File: SF19/97724
Job ID No: DOC19/832542
Your Ref: MOD 86-11-2007

RE: Notification of 4.55(1A) modification application – Sydney Opera House - Tours Immersive Digital Experience (DA 43-2-2004 MOD 5)

We understand that these works consist of repurposing existing back of house (BOH) catering, stores and staff facilities into a single front of house (FOH) space to facilitate construction of a digital visitor experience whilst the Concert Hall is closed for the building renewal works.

Project	SYDNEY OPERA HOUSE WHITE BOX
Title	DEMOLITION PLAN & SECTION

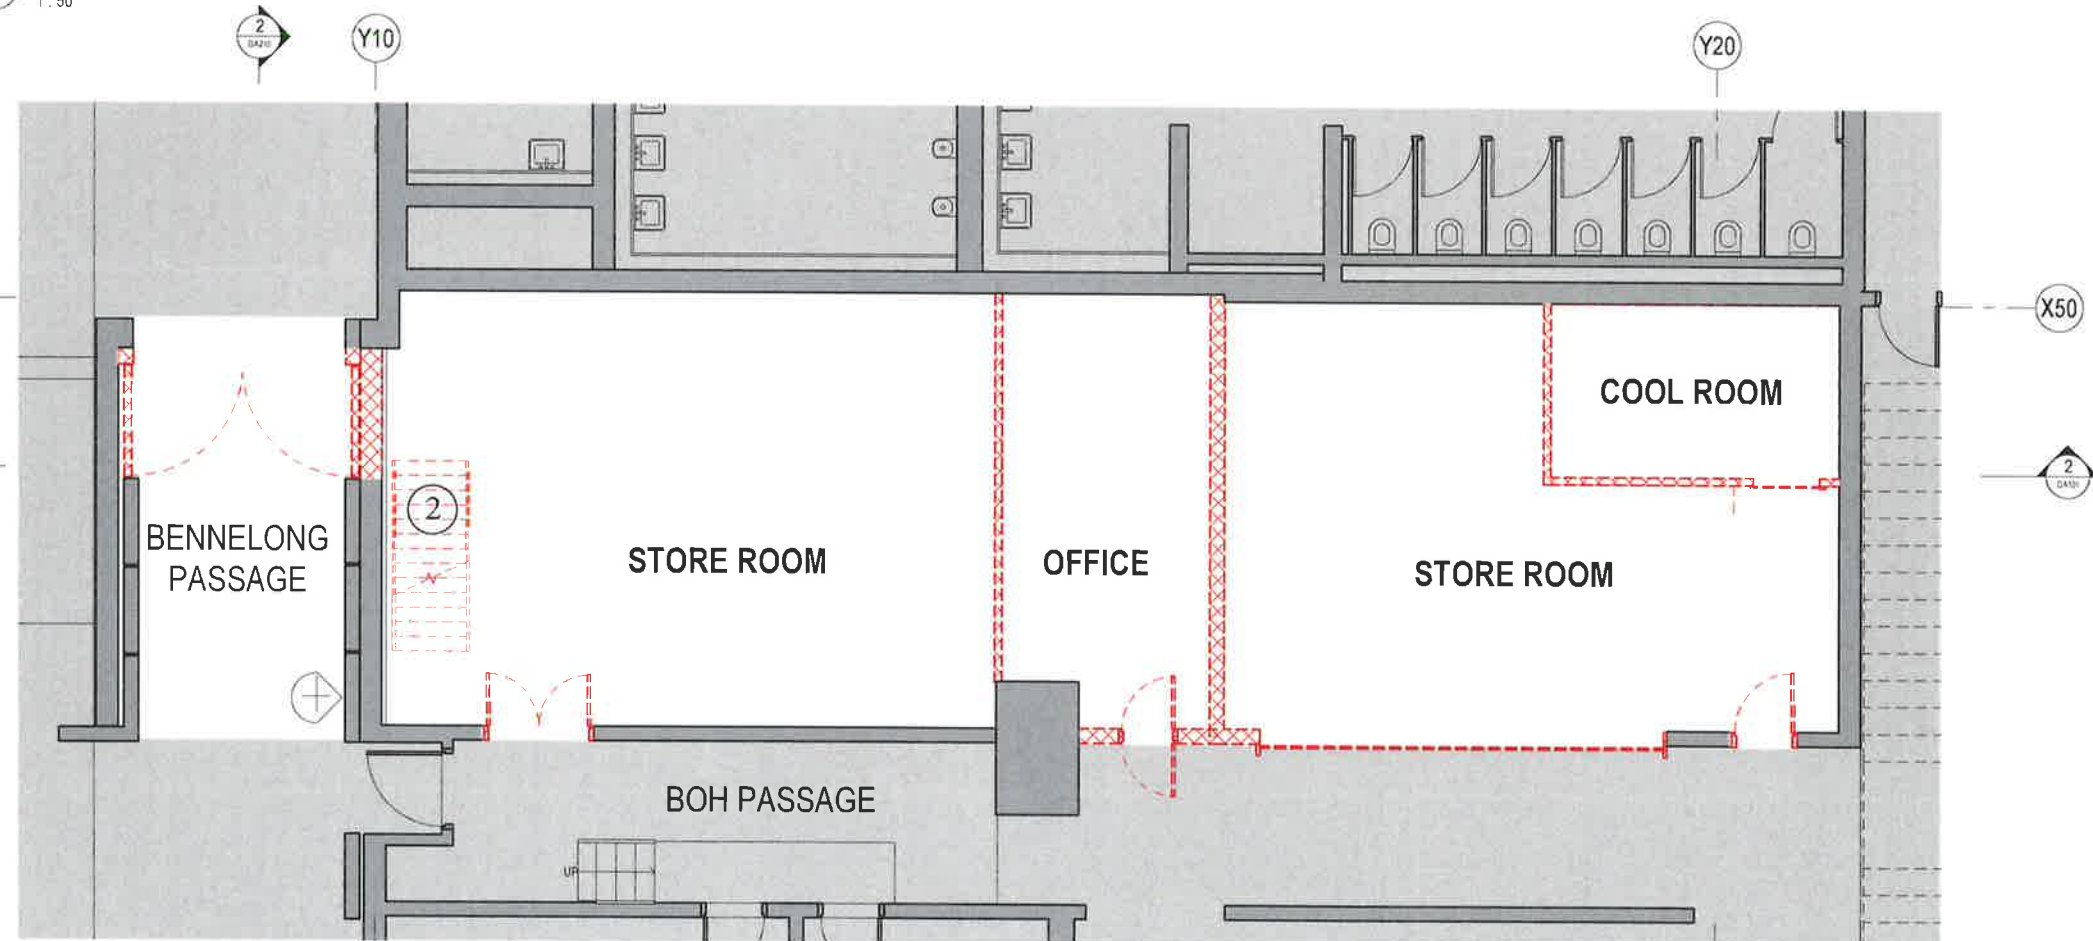
- The proposed works will have a physical impact to the SOH's original structure and fabric.
- The proposed demolition mostly consists of non-significant fabric, but includes original 1973 elements such as a door, roller shutter and concrete wall. Should the modification be approved, it is recommended that these elements are retained for potential reuse.

- Removed 1973 doors should be salvaged and stored for reuse.
- Detailing of the new opening within the 1968 podium structure should be finished to compliment the character, quality and design aesthetic of the SOH.

3 DA SECTION BENNELONG PASSAGE - PROPOSED
1:50

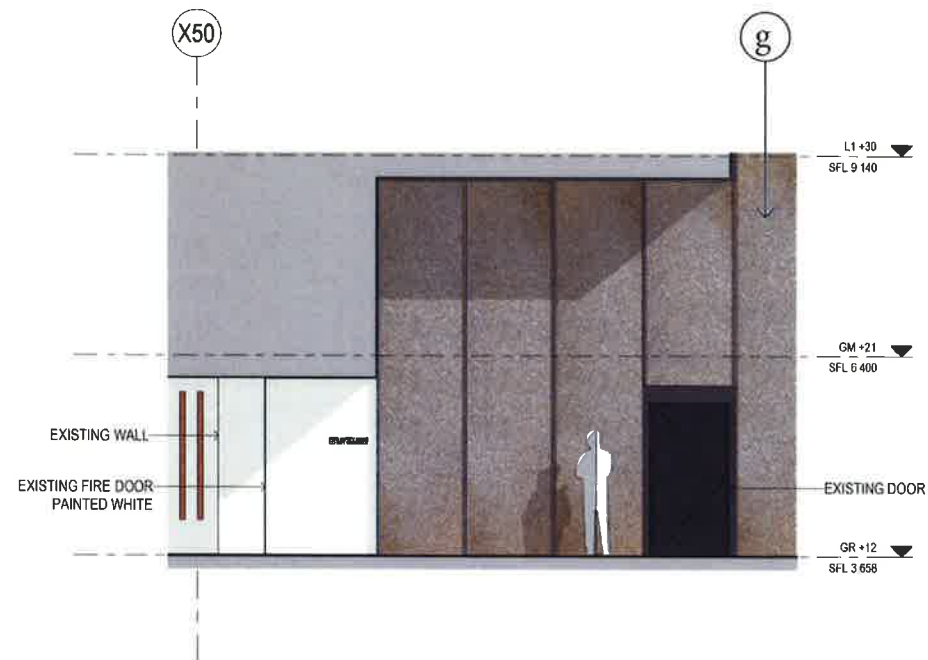
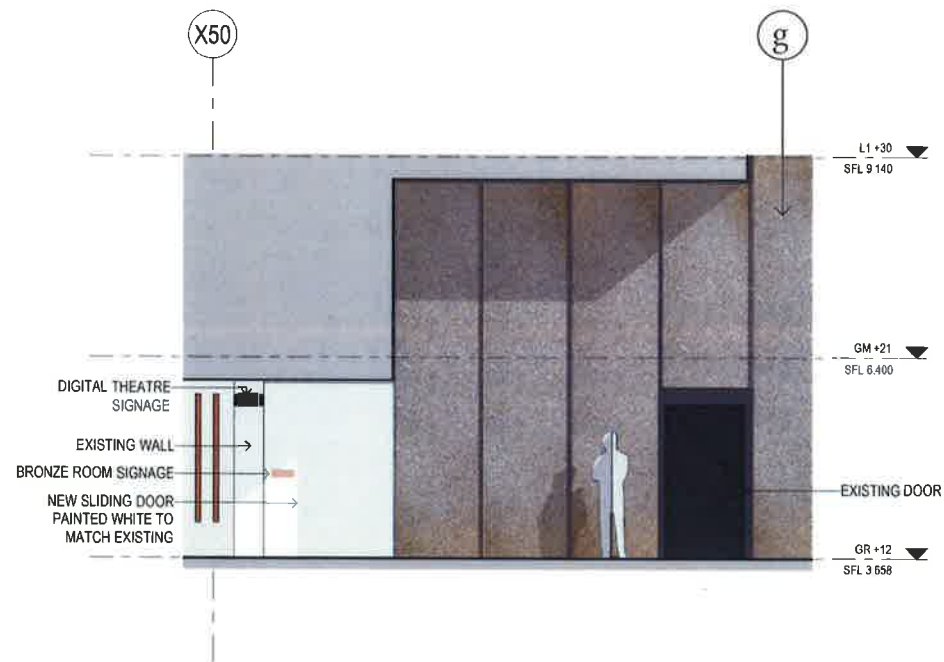
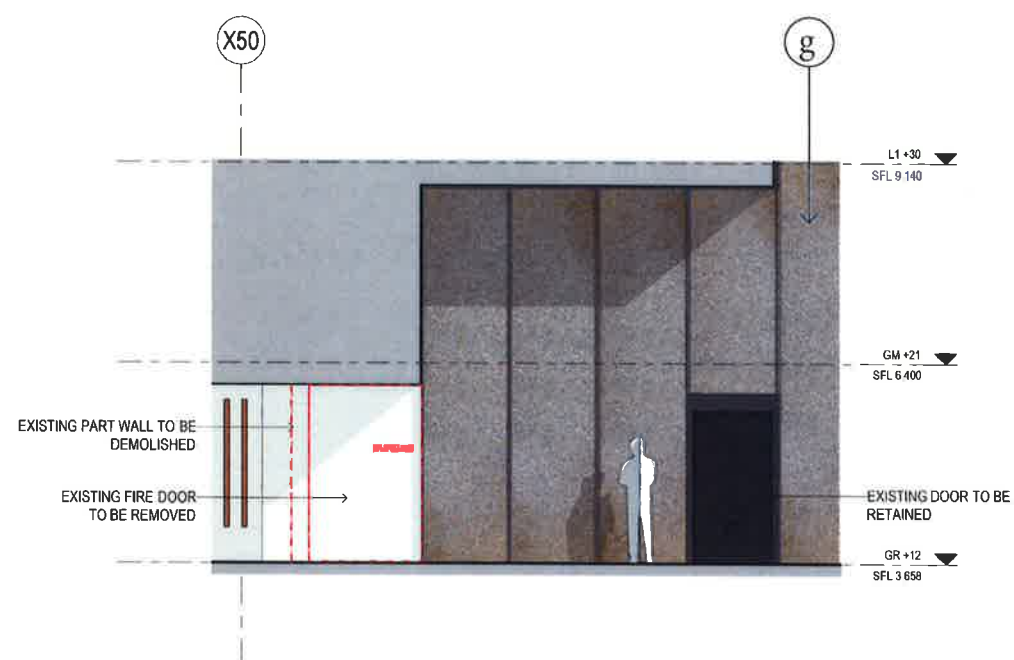
- It is also proposed to demolish a portion of the 1968 concrete podium structure along the Bennelong Passage to provide public access to the new Digital Immersion space. Whilst the demolition will impact significant fabric, the works will not impact the adjacent granite wall panels, concrete beams or the configuration of the Bennelong Passage, which is identified as exceptional significance.

- It is unclear how the new opening within the 1968 podium structure will be detailed including to the cut edge. Further detail should be provided as part of the application under the *Heritage Act 1977*. Similarly, details should also be provided for the new fire curtain to ensure it is neatly recessed and does not impact adjacent fabric, including concrete walls.

- The new fire curtain within the Bennelong Passage should be neatly finished including any guiding tracks, and not impact significant fabric including concrete walls. It should also be finished to compliment the character, quality and design aesthetic of the SOH.
